From: Ian Wightman <[REDACTED]>
Sent: 15 August 2019 17:49
To: Simon Davis <Simon.Davis@arun.gov.uk>
Cc: Chris Purdy (MHA) <[REDACTED]>; Harvey Hillary <[REDACTED]>; Martyn White <Martyn.White@arun.gov.uk>; Harry Groucott (MHA) <[REDACTED]>
Subject: RE: Nyton House Care Home - AL/42/19/PL & AL/43/19/L

RE: Nyton House Care Home - AL/42/19/PL & AL/43/19/L

As part of the application to provide additional dementia care at Nyton House, Jane Jones Warner Associates were kindly asked to look at the proposals and offer some commentary on the scheme and consider potential solutions.

ELEVATIONS

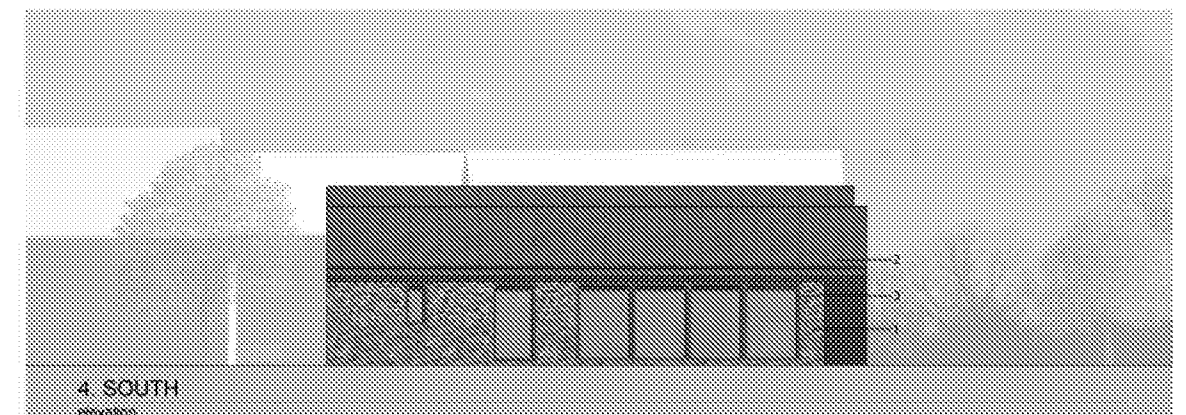
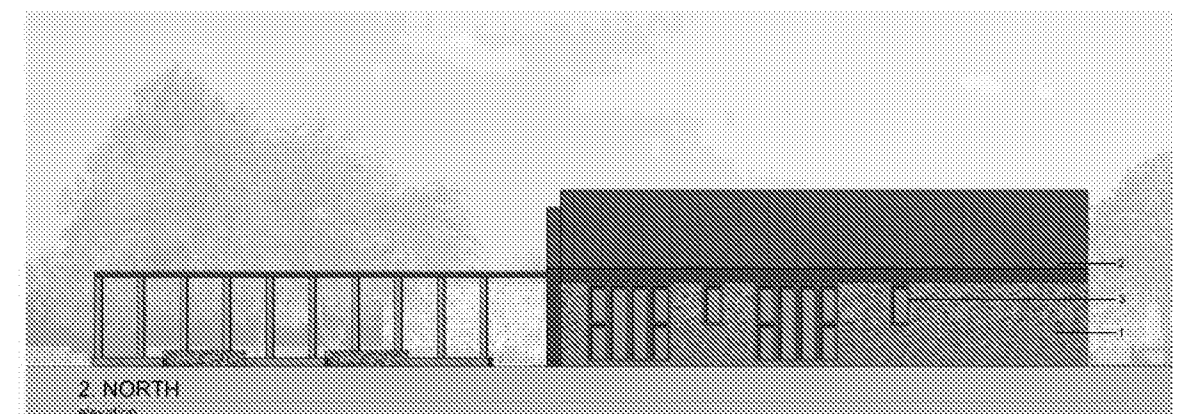
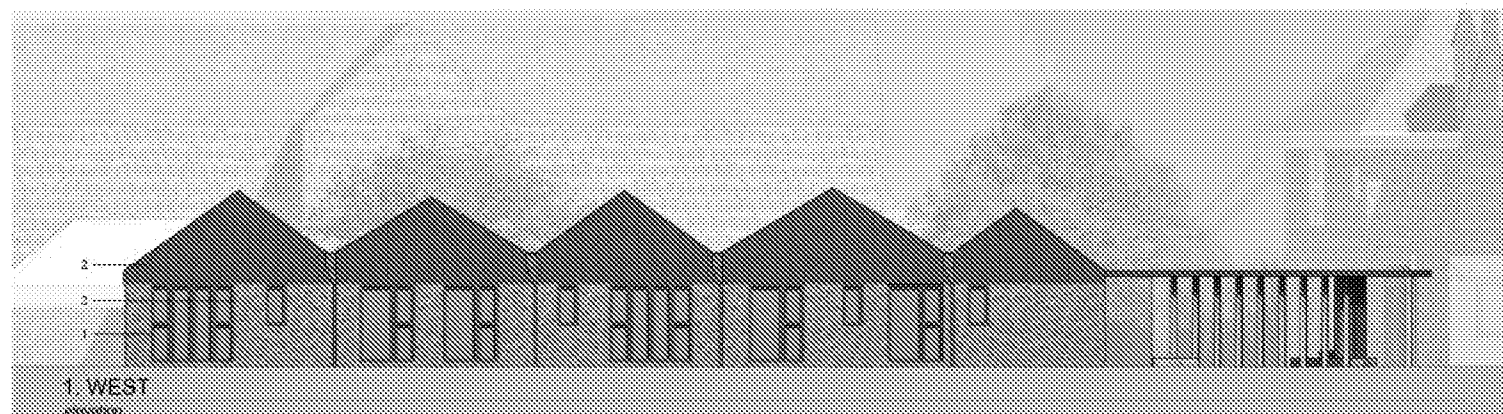
The building form and scale is clearly subservient to the neighbouring historic buildings and does not compete with them. As can be seen in the west elevation especially, the new development is low level.

1. View from Knighton Grange (At 1.8m Height)

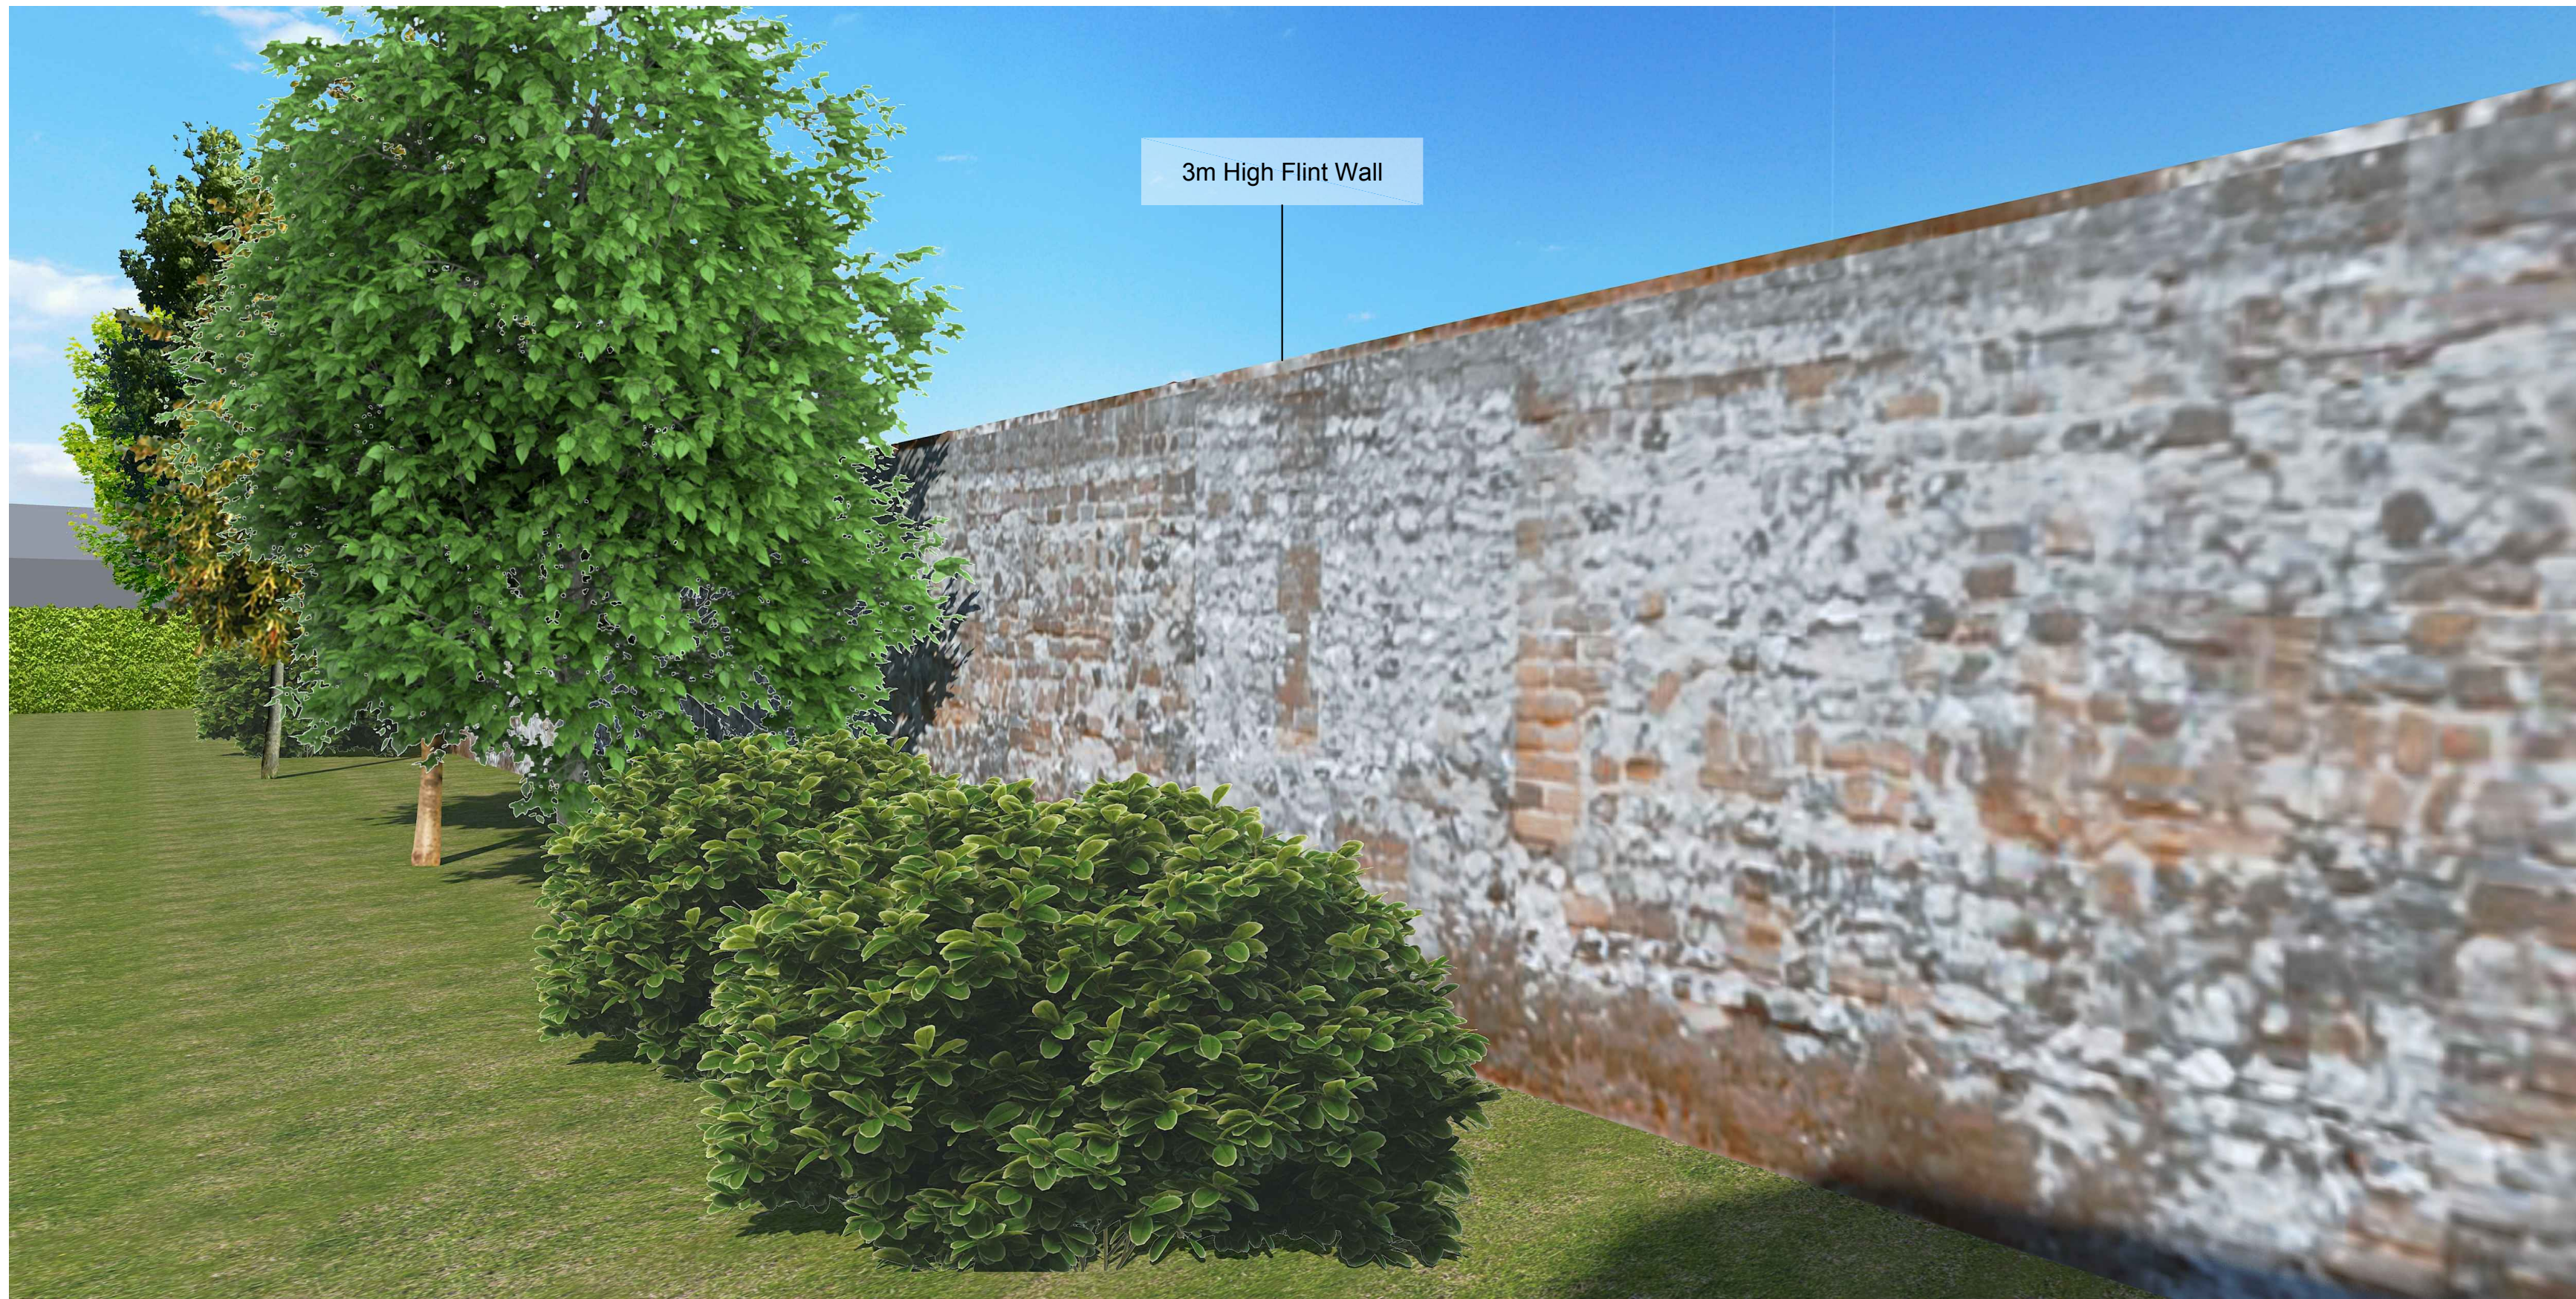
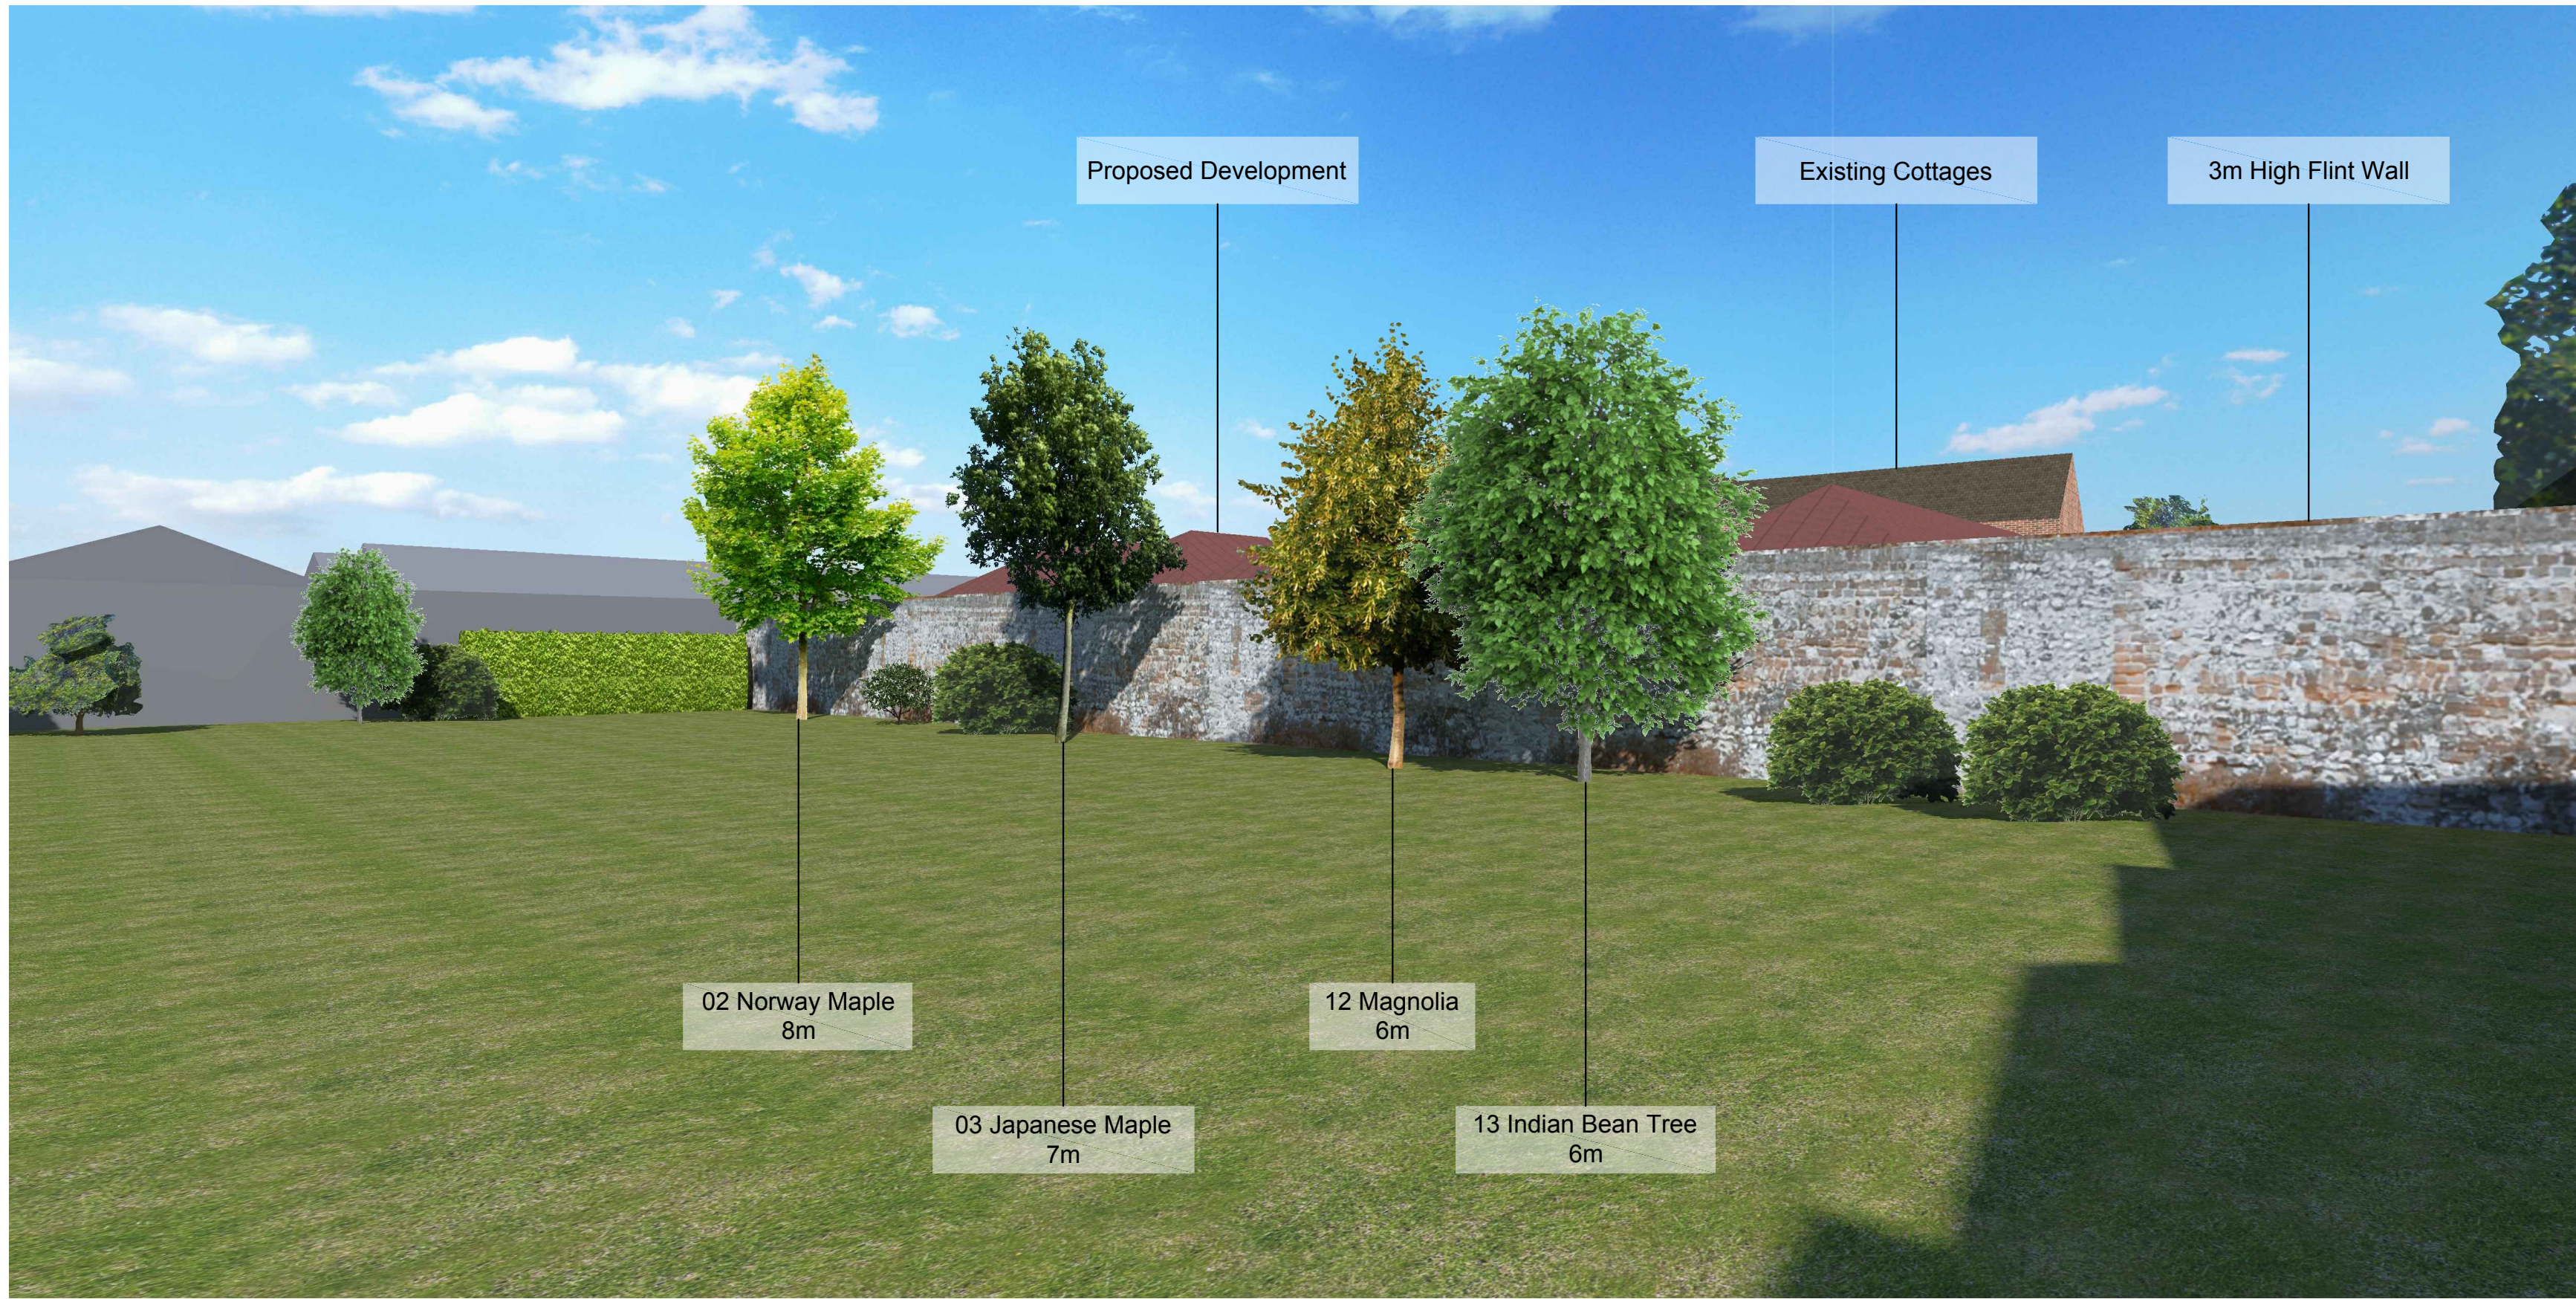
The design as it stood was largely as proposed now, with the exception of the roof which was gabled at both ends and thus clearly visible from Knighton Grange Cottage. Part of the problem here was the potential visibility of the gable ends and their visual impact on the large boundary wall which separates the two properties. The gable roofs created a saw-tooth type profile which was not sympathetic in this context.

The solution here was to hip the roofs and thereby push the ridges back so that they were less intrusive. The hipping also resulted in a more recumbent and quieter roof form that turns its back on the cottage and it is therefore much quieter in visual terms. Whilst the roofs would still be visible, the use of good quality clay tiles would be appropriate in this context.
